From: Martyn White <Martyn.White@arun.gov.uk>
Sent: 01 July 2020 16:48
To: Planning.Responses <Planning.Responses@arun.gov.uk>
Subject: BR/93/20/PL

BR/93/20/PL

Change of Use from office (B1(a)) to 1 No. dwelling & the provision of new garden boundary wall to the South of property. This application affects the setting of a Listed Building & affects the character & appearance of the Upper Bognor road & Mead Lane Conservation Area

Martyn White
Principal Conservation Officer, Planning Services

REV	DATE	AMENDMENT
PROJECT MORDINGTON COTTAGE CHICHESTER UNIVERSITY, BOGNOR REGIS CAMPUS, UPPER BOGNOR ROAD, BOGNOR, W. Sx. PO21 1HR		
DRAWING EXISTING & PROPOSED PLAN		
Date	15-04-20	Drawn By KOB
Scale	1: 100	Iss. App. By KOB
Drawing No	003	File Location KB/MORD/003/001

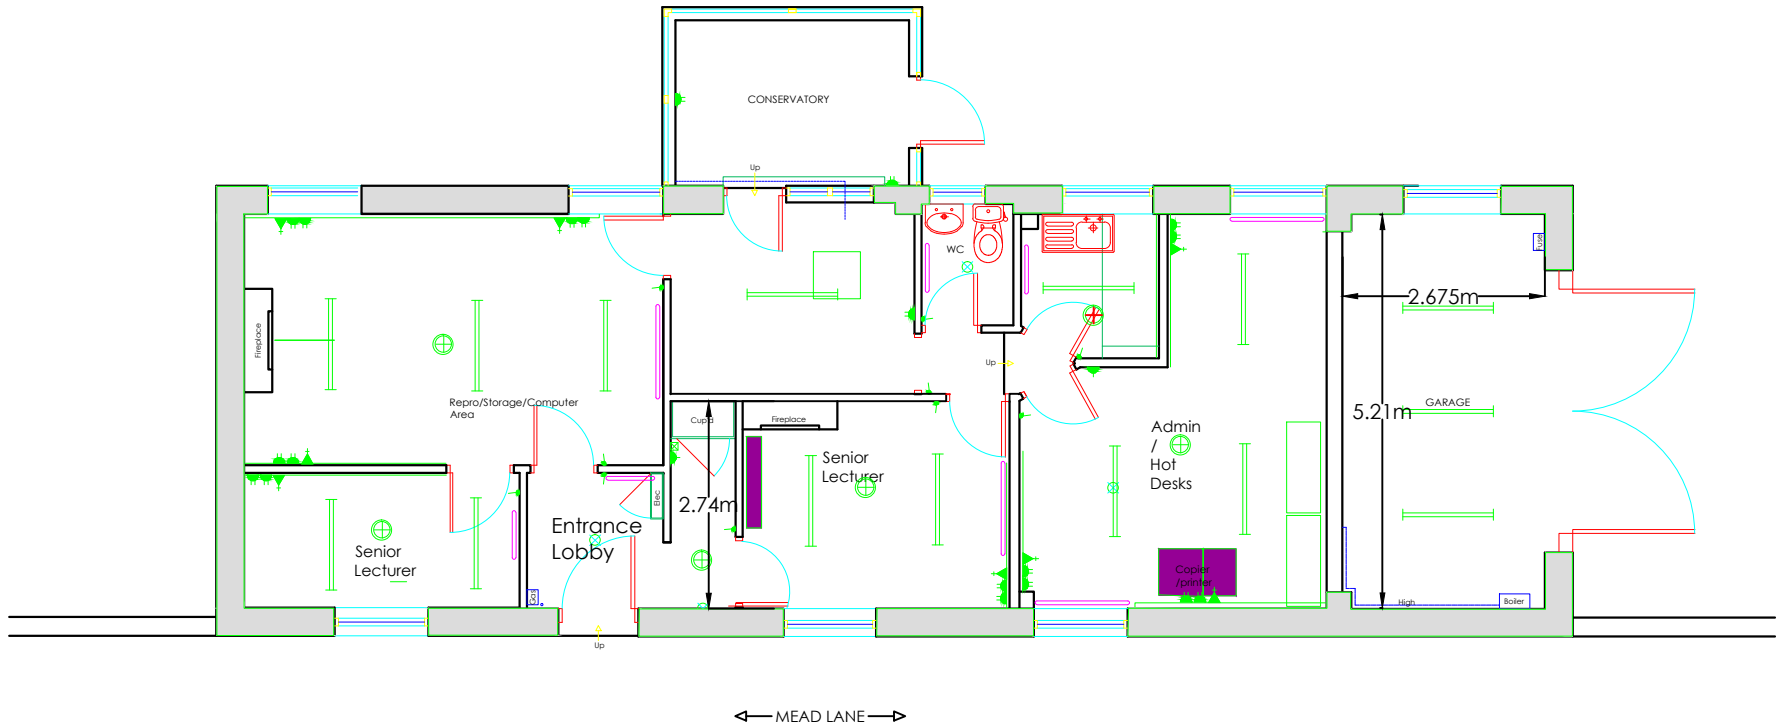
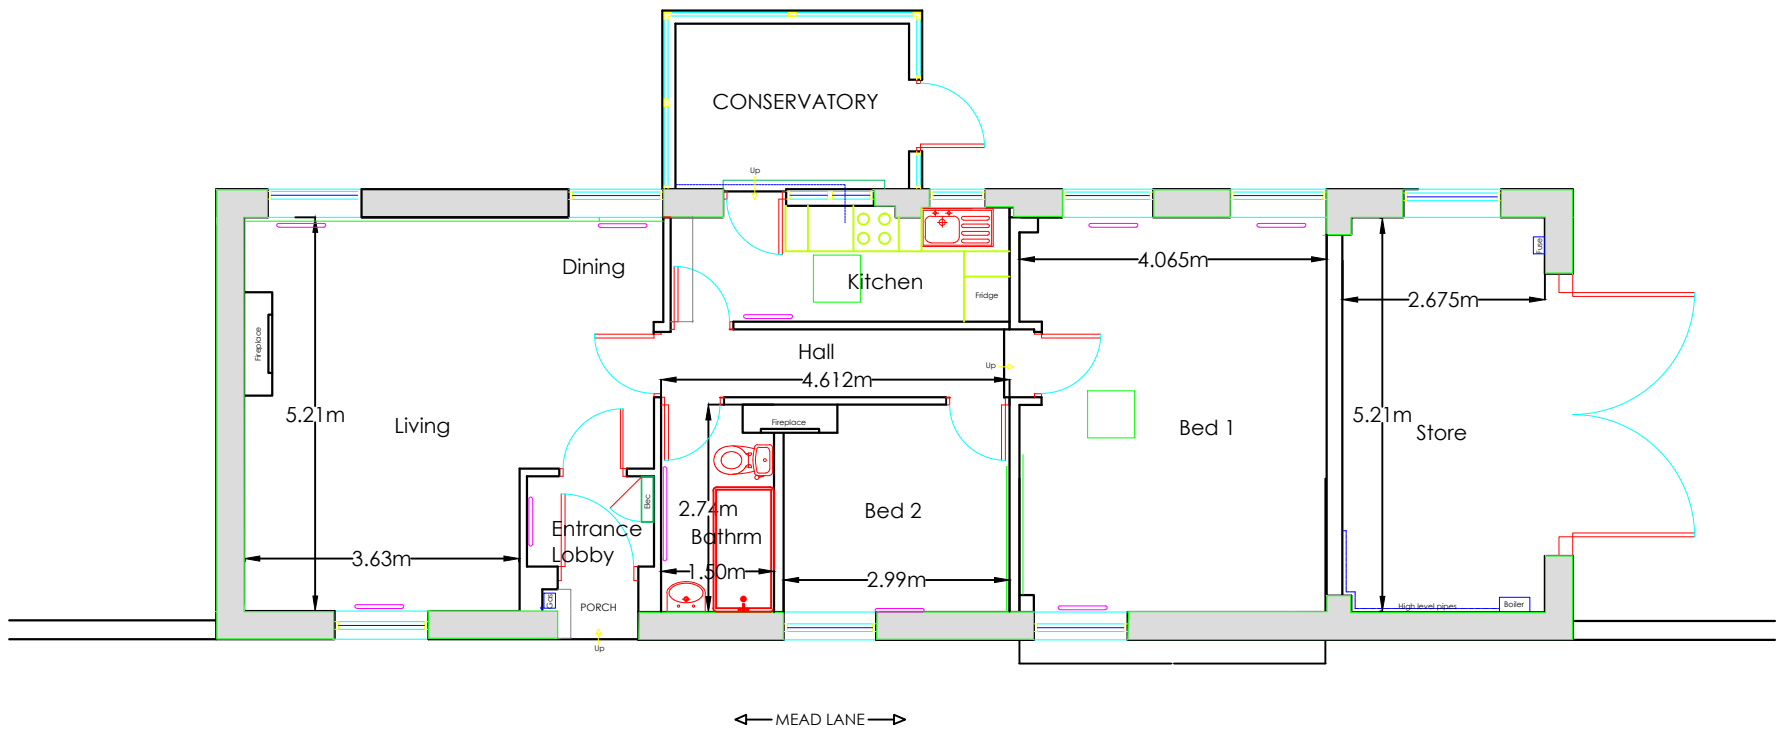
It is not clear if the existing boundary gates will be replaced as part of the proposal. If they are to be, you may wish to condition details of the gates and their treatment in order to ensure that they reflect the character of the building and local area.

PROPOSED SOUTH ELEVATION - showing garden walls (new & extg)

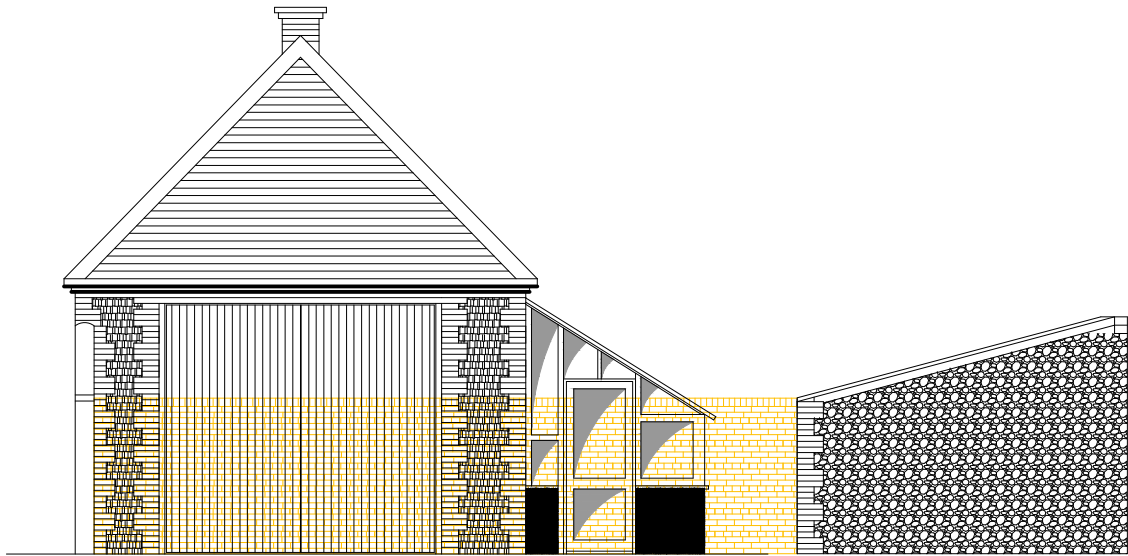
It is considered that the proposals will enable the cottage to be returned to a more appropriate use, whilst ensuring that the features which make it special are preserved. It is positive to read in the heritage statement that the existing windows and doors will not be altered, and that an appropriate wall will be constructed when securing the curtilage. I also note that the applicant wishes to agree the bricks for the boundary wall on site in order to secure the most appropriate ones. This could potentially be conditioned.
